Planning Application Ref: R/197/20/OUT

Location: Croft Works, 52 Mill Lane, Rustington, BN16 3JN

Description of works: Outline application with some matters reserved for the demolition of existing dilapidated storage buildings & erection of 2 No. detached 3-bedroom chalet bungalows with associated car barns, gardens, car parking & landscaping (resubmission following R/117/20/OUT).

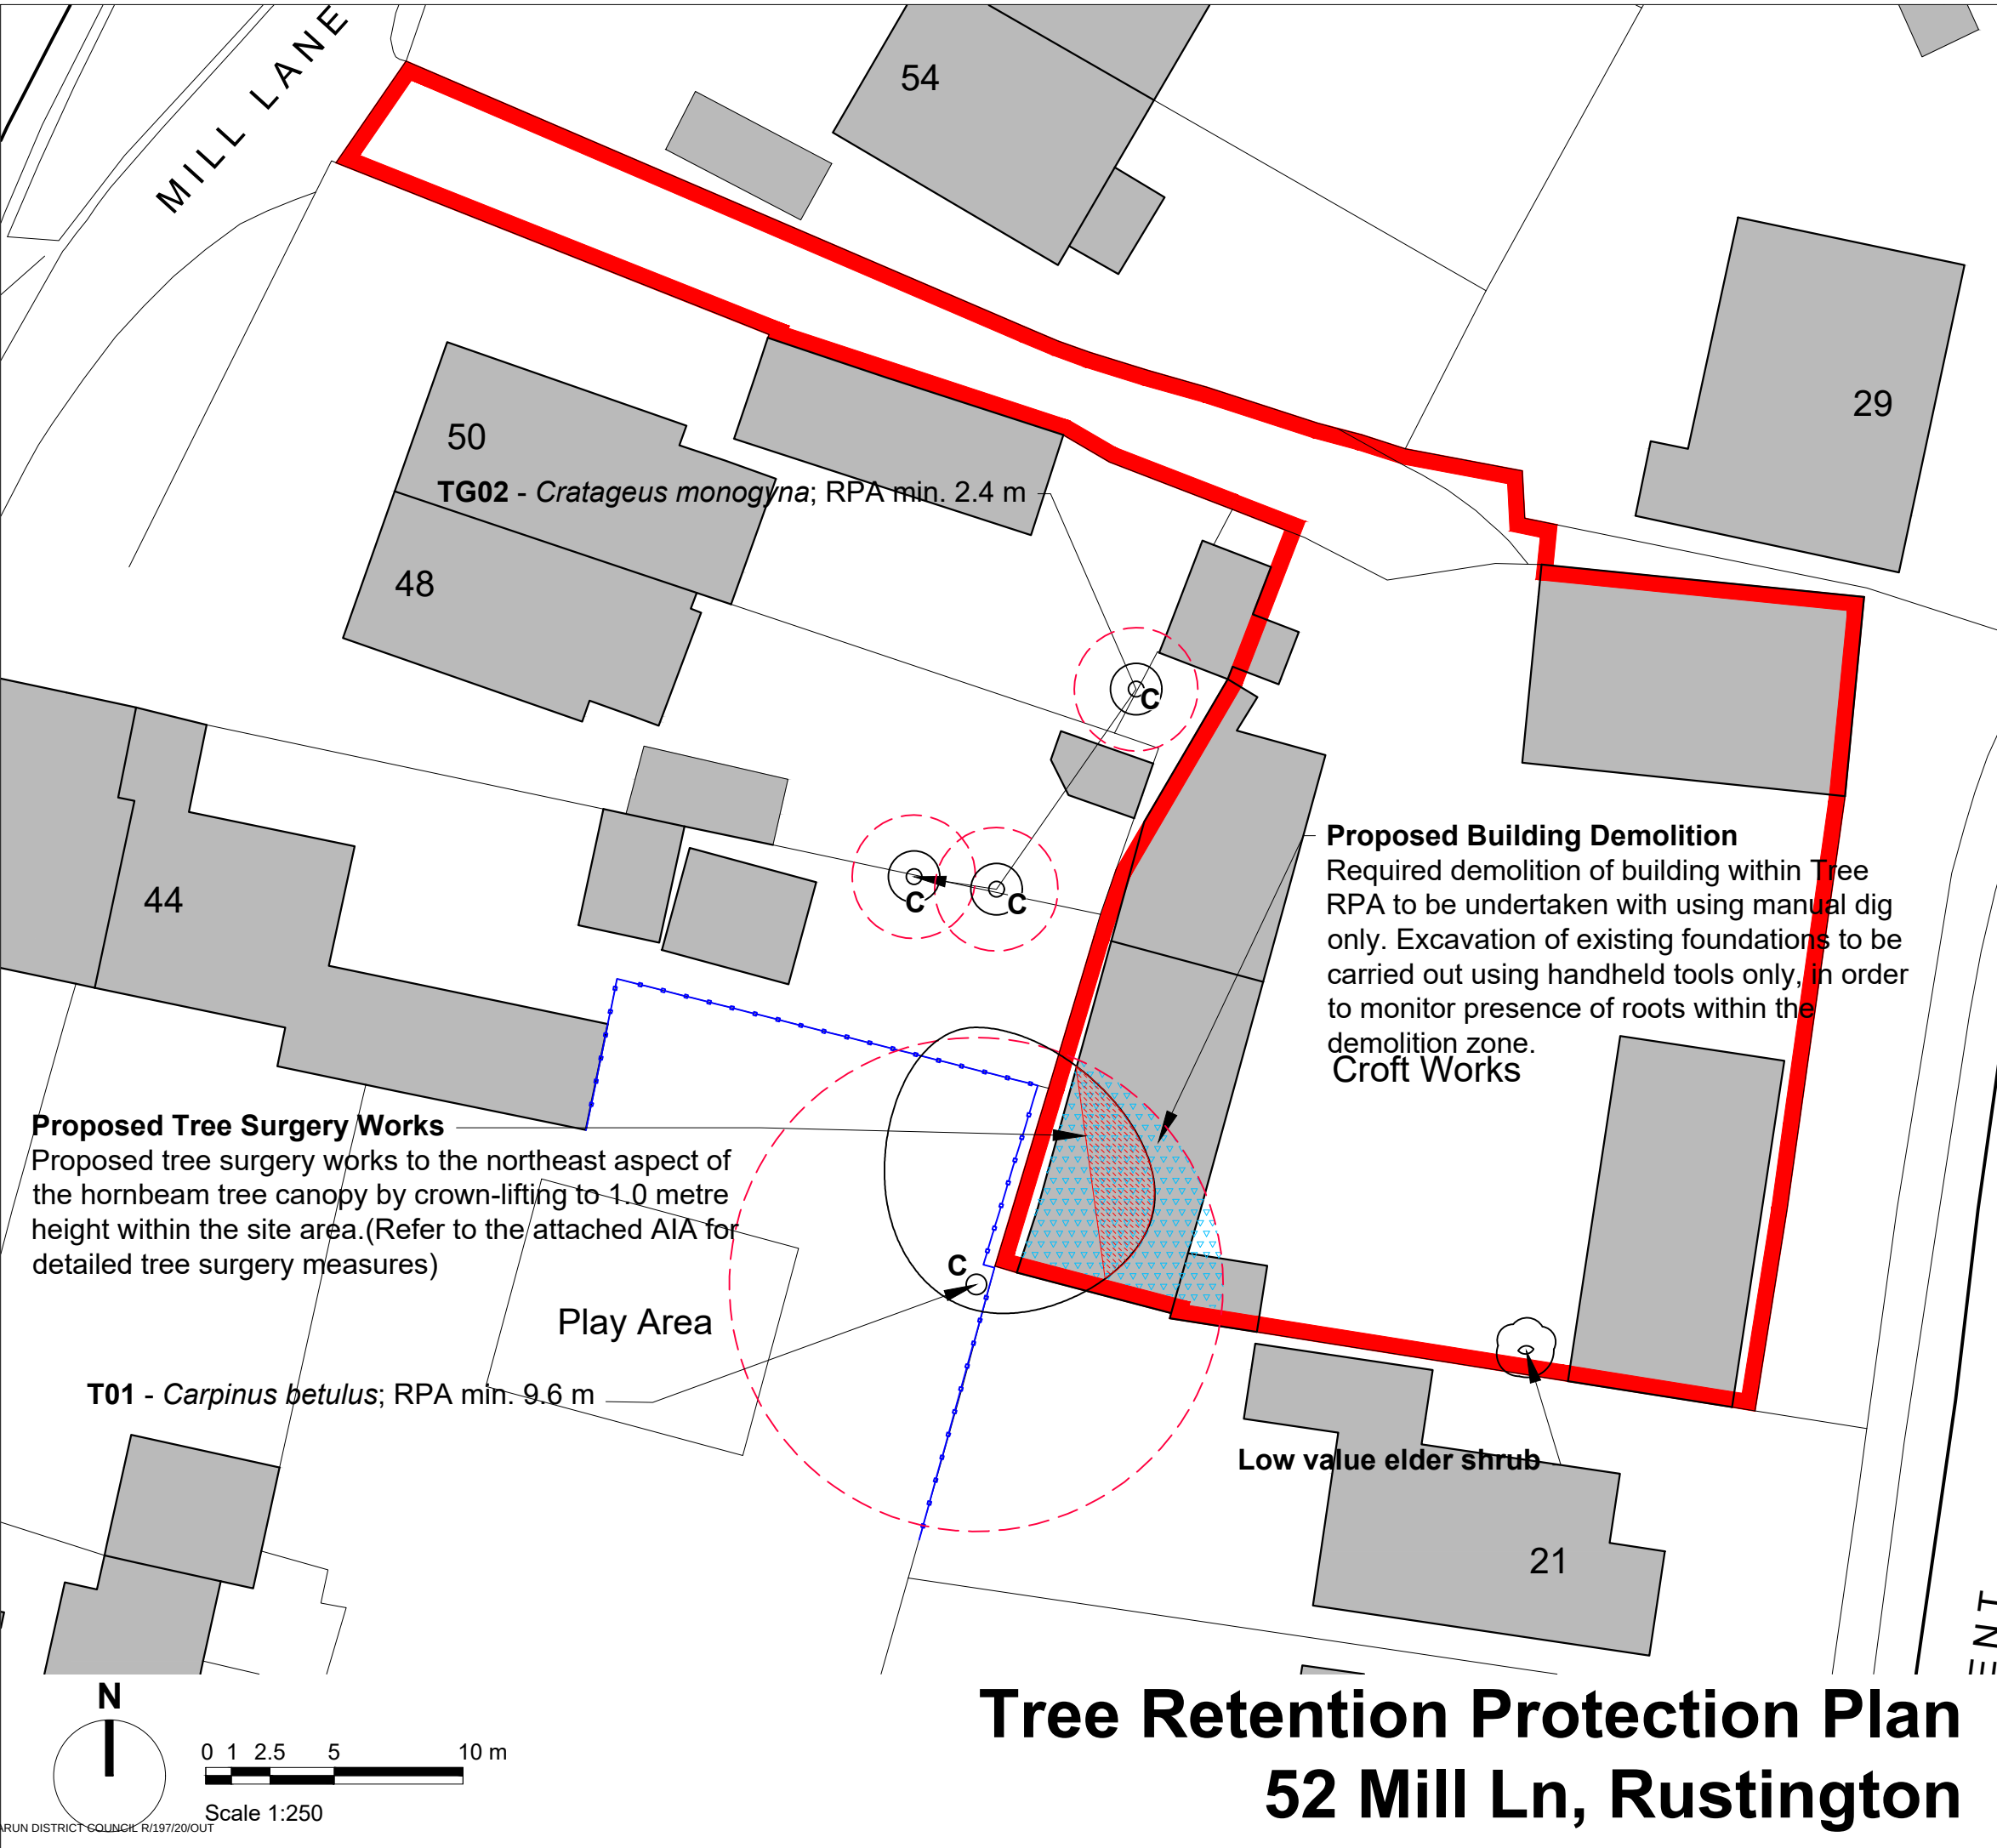
- Aerial photography suggests large trees are off-site to the south-west, visible from publicly accessible land and whose nominal root protection areas could be far-reaching. This needs to be established with a tree survey.

- 3rd party trees that overlap this site could be adversely affected by the proposals. There is insufficient arboricultural information submitted with the application. As such, were this application to now proceed, we will not have sufficient information to guarantee such trees would be adequately respected and protected. **Resolved.** The applicants have employed Lizard Landscape Design Ltd to prepare an Arboricultural Impact Assessment & Method Statement (AIA/MS) along with a Tree Protection Plan for this project.

- Drainage and service-runs in and out of site have not been shown so there is potential for root protection area incursion to satisfy those requirements. As described in the AIA/MS existing service lines are to be utilised and new routes will bypass root protection area of significant off-site tree (T01).

- The principle of development as described is certainly achievable without undue detriment to off-site trees, although we are yet to have sight of the necessary arboricultural report and plans to demonstrate this has been properly considered. **Resolved.**
- The applicant has adequately assessed the potential impact of this development on a long-established 3rd party tree which overlaps the site and provided the necessary arboricultural report and plan which describes/illustrates how they will mitigate the risk of damage, in accordance with **British Standard 5837:2012 - Trees in relation to Design, Demolition and Construction**. As such, I can now support the scheme.

1. All activity at the site is to be carried out in strict accordance with: - **Arboricultural Impact Assessment and Method Statement, ref. LLD2098-ARB-REP-001, Rev 00, 03 December 2020** and **Tree Retention Protection Plan, ref. LLD2098-ARB-DWG-001, Rev 00, 03 December 2020**.
